From: Contact Centre (CRM) <contact@ribblevalley.gov.uk>
Sent: 09 January 2026 09:05
To: Planning
Subject: Planning Application Comments - 3/2025/0997 FS-Case-783541578

Planning Application Reference No.: 3/2025/0997

Address of Development: Land off Henthorn Road, Clitheroe BB7 3BY

Applicant: Gladman Developments Ltd

Drawing file: planx_downloads / 25_0997_3_Proposed_Access_Plan.pdf

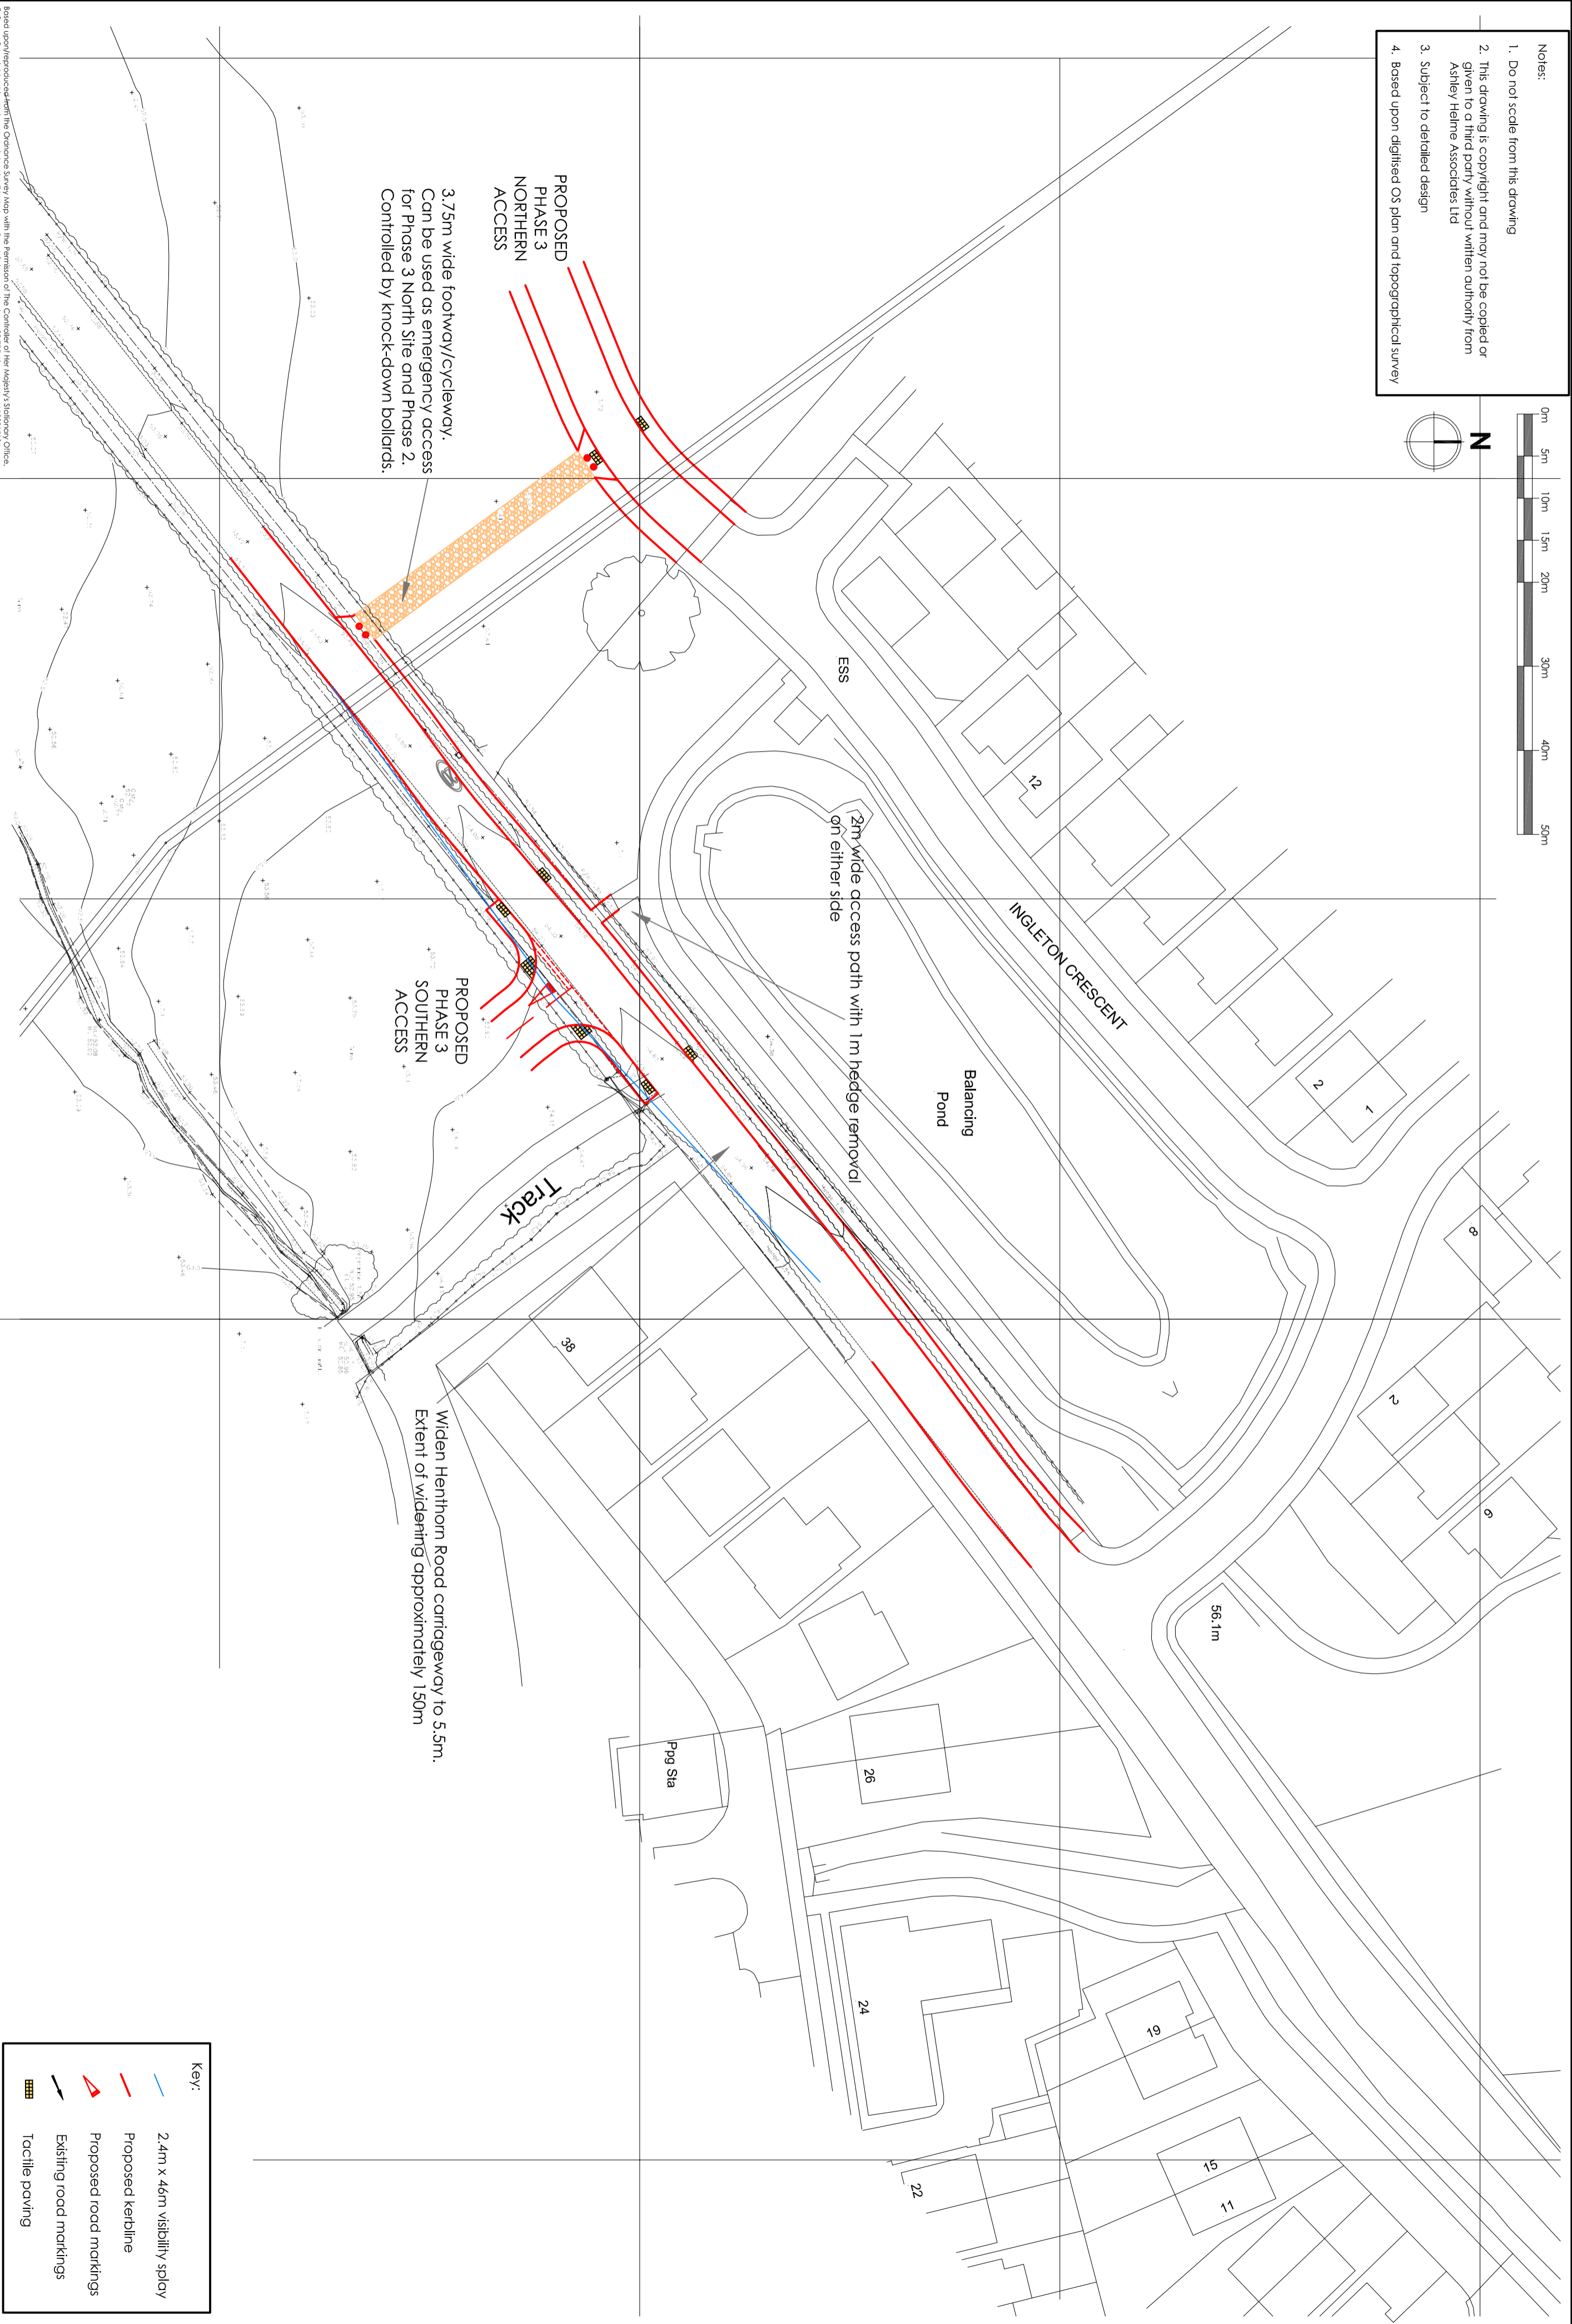
Comments: Site Access via Ingleton Crescent, is not fit for purpose, due to the width of the road and close proximity to houses, Ingleton Crescent would not safely sustain this level of traffic and noise. It's almost impossible to get 2 cars past each other never mind large construction vehicles. Going forward for the same reason (width of Ingleton crescent) foot only access should be provided to the new development if approved also vehicle access should be from Henthorn Rd. At the moment it's only by luck that there hasn't been a serious accident to date on Henthorn.

Comments: House owners within Montague Place have been raising a number of issues over the proposed Gladman development covering both sides of Henthorn Road, beyond where Montague Place and Pendleton Grange are situated. A primary concern being the proposed entrance to the more northerly element of the development, via Waterfall Gardens and Ingleton Crescent.

Gladman's latest proposal would have all traffic from this part of the development (40-50 houses) entering and exiting via Ingleton Crescent and Waterfall Gardens. Waterfall Gardens already takes all of the traffic in and out of Montague Place, and Ingleton Crescent is currently a cul-de-sac with a small number of houses and as such, is used as a play area for the children within the estate and an area where wildlife from the pond in front of the it (ducks, geese, herons and occasionally deer) roam freely. This crescent will all be heavily affected by this proposal and the risk of children being hit by the significant increased traffic flow will be heightened.

What we are asking is that the proposed traffic entrance be changed from entering and exiting via Waterfall Gardens and Ingleton Crescent, to entering and exiting directly from Henthorn Road, as it is being proposed for the more Southerly element of the development. We are also asking that the currently proposed traffic entrance and exit via Waterfall Gardens and Ingleton Crescent be used as a footpath, which is currently being proposed to enter and exit directly onto Henthorn Road, a very dangerous proposal as traffic including; cars to and from the Reclamation Centre, trucks collecting and dropping off skips and fluid tankers to and from the Water Treatment Plant, use this road multiple times on a daily basis and the footpath is shielded from view for both pedestrians and traffic.

Comments: As someone who lives on the Montague Place estate it would be hypocritical of me to object to the proposals. However I have two concerns, the first being the proposed access along Ingleton Crescent. This is a cul de sac that allows children to play in the section leading to Hatch Brook Avenue. Moreover, the local wildlife that inhabits the sustainable drainage area, mainly ducks, is often found in the roadway. I note that access to the southern site is from Henthorn Road. My second point relates to Henthorn Road and the traffic document, on which the applicant relies in its rebuff of concerns regarding traffic problems on this road. The document appears to rely heavily on historic data, some 6 years old and introduces much irrelevant data from other sites and road junctions in Clitheroe. Traffic counts are used as evidence of traffic flows, but these were carried out once, in 2024, then modelled. It is good practice to carry out a variety of counts, at different times, and at different times of the year, I would suggest that the results would be markedly different if this were done. I note that the applicant has proposed certain alterations to Henthorn Road which would be helpful with traffic flow

access to the development through Ingleton Crescent which simply is not wide enough to absorb the additional traffic. It would also create concern for the wildlife and water fowl living in the pond, hedgerows and wildflower area at the bottom of the road.
